Application No: WA/93/20/PL
Site Address: Land East of Tye Lane Walberton BN18 0LU
Description of works: Alternative vehicular access off Tye Lane & emergency access off Avisford Park Road, along with minor highway works following WA/95/18/RES. This site is in CIL Zone 2 (Zero Rated) as other development.

Thank you for your internet representation made on 14th May 2021 which has been recorded as an objection with the comments as follows:

AVISFORD PARK ROAD

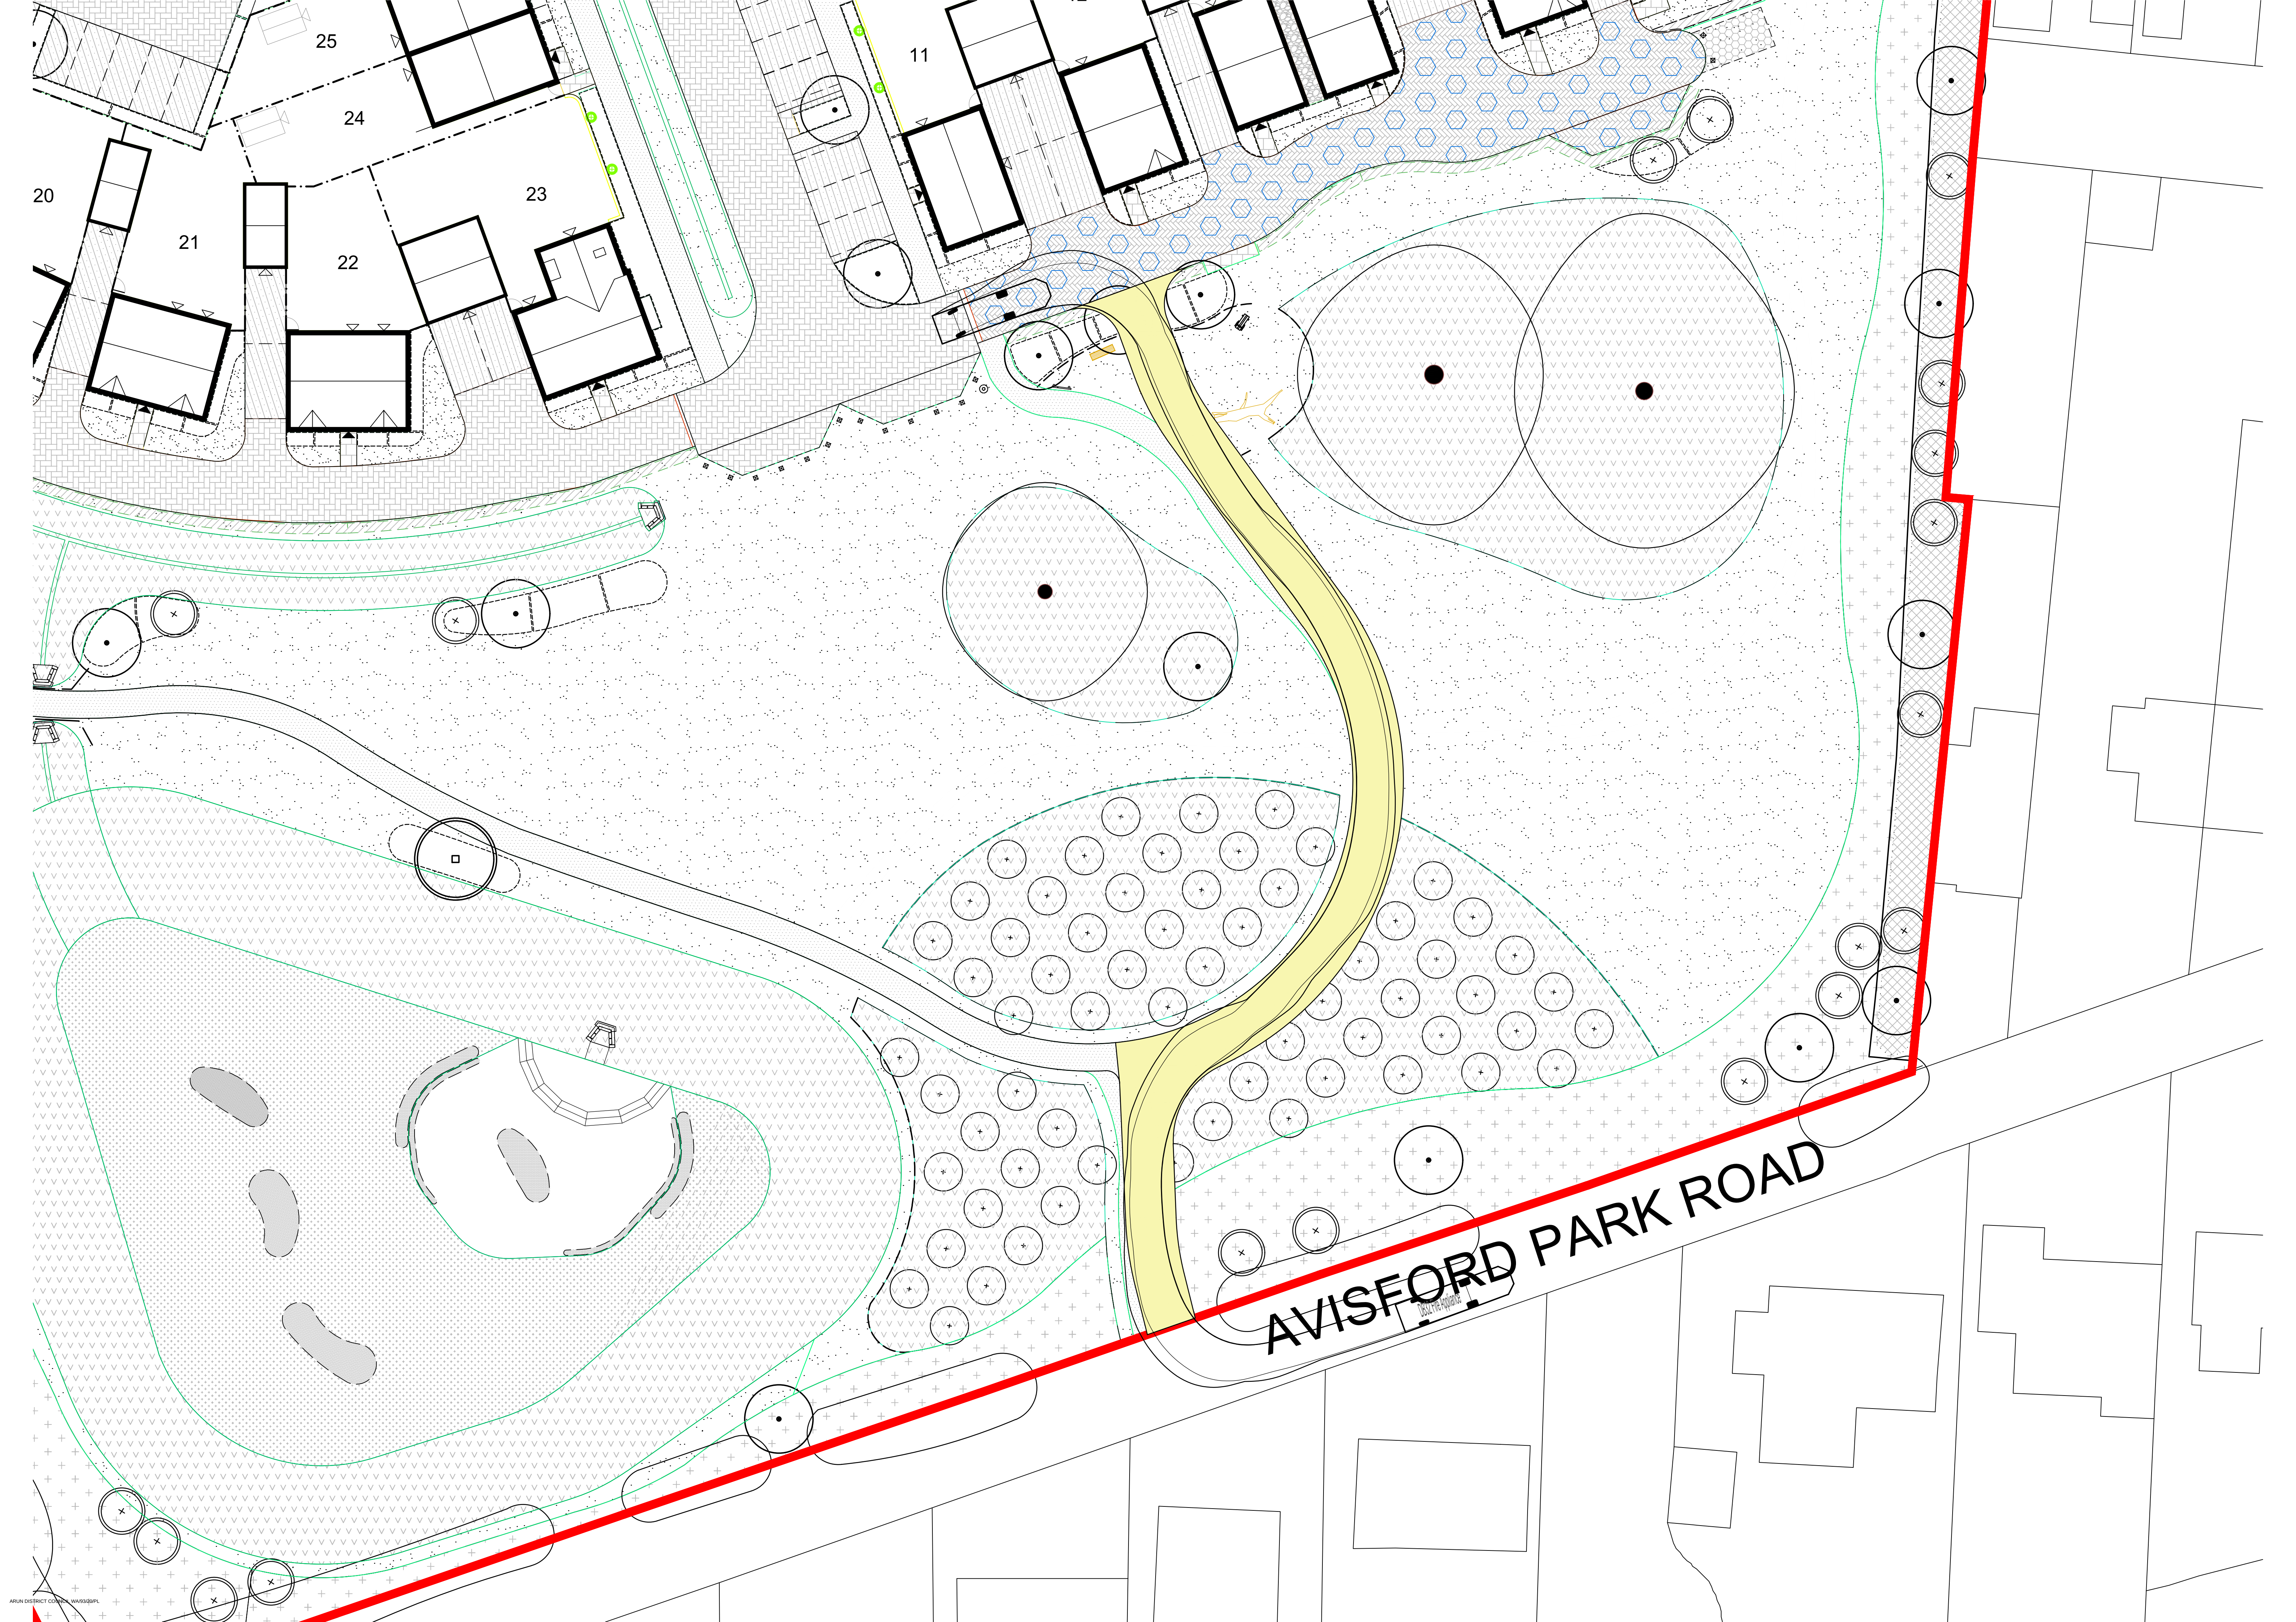
Alternative Emergency Access via Avisford Park Road is inappropriate as it is a narrow unsurfaced and unadopted road. The application shows 2-way access which is wrong as it is only wide enough for one vehicle at a time. The shown left turn into AG is not possible as Avisford Park Road is only accessible by vehicles from the Yapton Lane end.

The widened path proposed for emergency vehicles is in the public open space and they have not made clear how this will impact safety.
